## MOD5 SSD7348

### Response to Council submission on MOD5 - SSD7348, dated 9 September 2020

Drawing No.	Project No.	Issue
15-272-C2030	15-272	A3

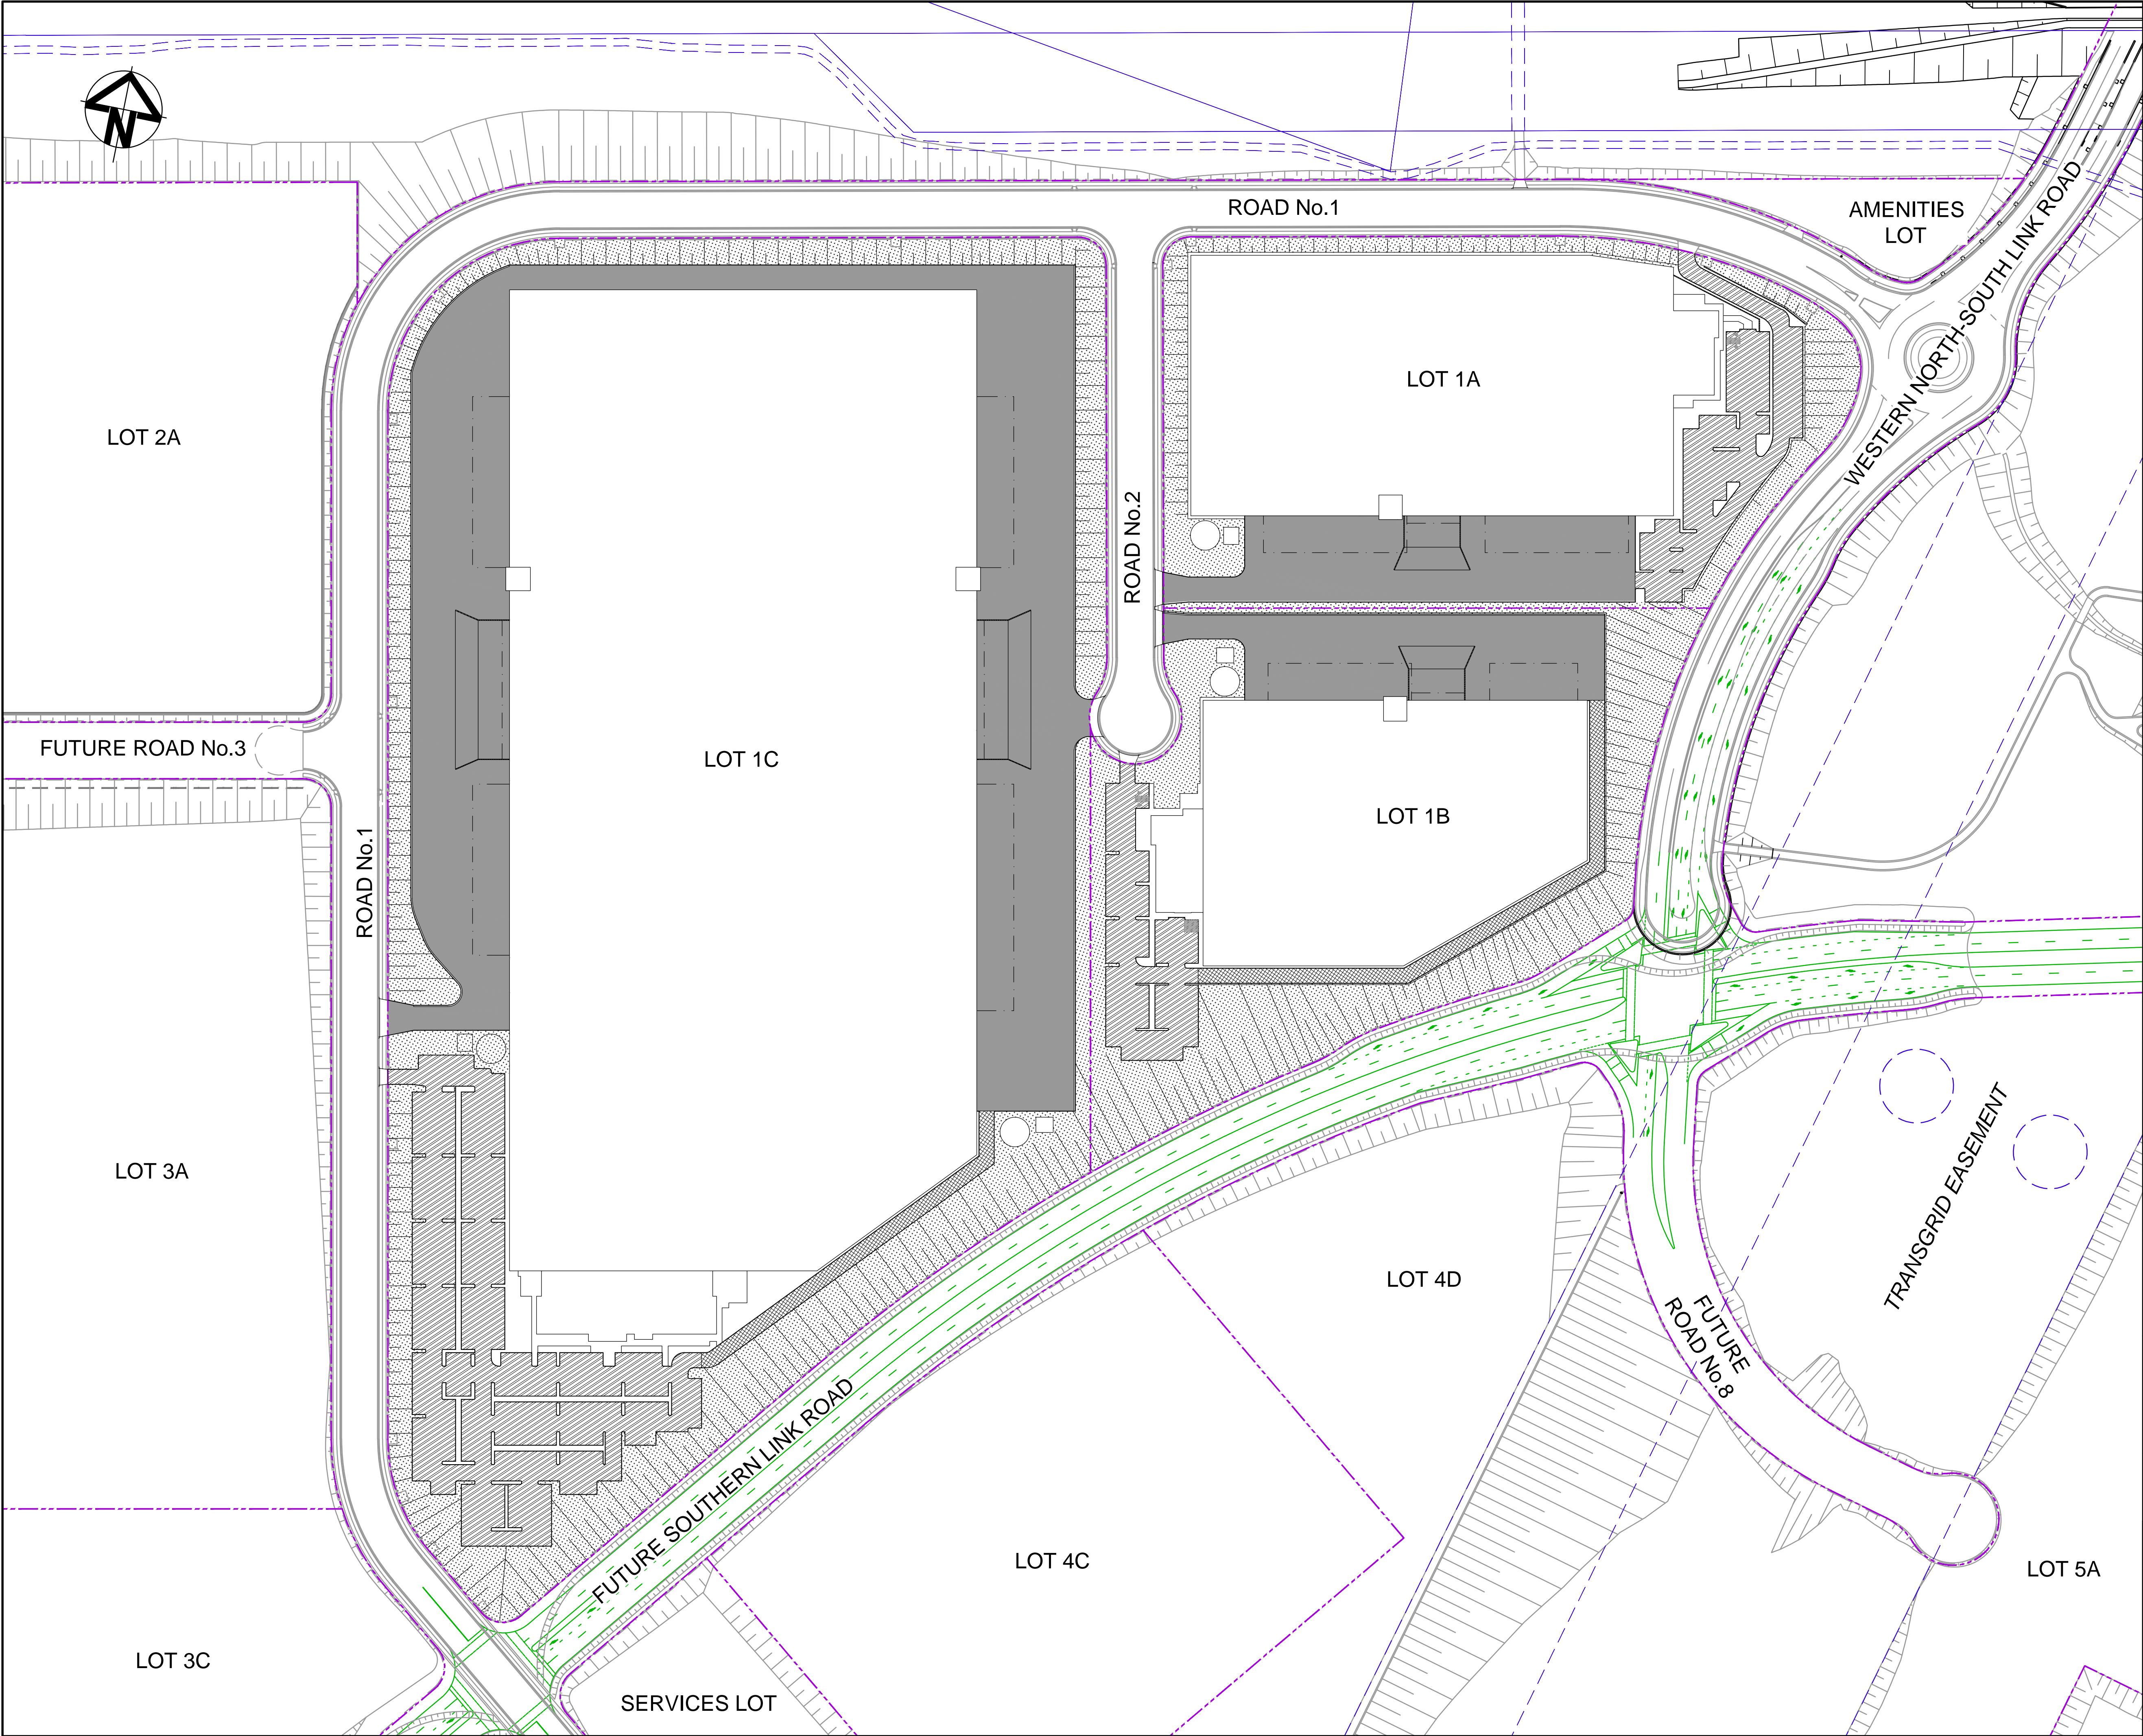
4) The widening of the SLR road reserve adjoining Lot 2B west of Road No 1 (sheets C2030 & C2023) will also impact batter slopes within this area. Details have not been provided.	<ul style="list-style-type: none"> <li>The subject subdivision has nothing to do with Lot 2B. The subdivision applications only affect 1A &amp; 1B-1C.</li> </ul>
The proposed plans submitted in support of the Mod 5 application, as a consequence of required changes to the proposed lot configurations, are not suitable and require further amendment due to further widening required by TfNSW. Noting that lot dimensions for road reservation widening is required, this widening cannot be at the expense of the landscape setback approved in the above SSD determination. Where the landscaping setback is impacted to less than the minimum 10m approved, reconsideration and amendment of the overall development arrangement is considered to be necessary.	<ul style="list-style-type: none"> <li>As mentioned above, TfNSW do not know which design option they will proceed with. Goodman suggest the application be approved as-is. Once TfNSW have approval to proceed with construction and the design is confirmed, the relevant authorities and parties can discuss how council's requirements are satisfied. Refer to <b>Annexure C</b>.</li> </ul>
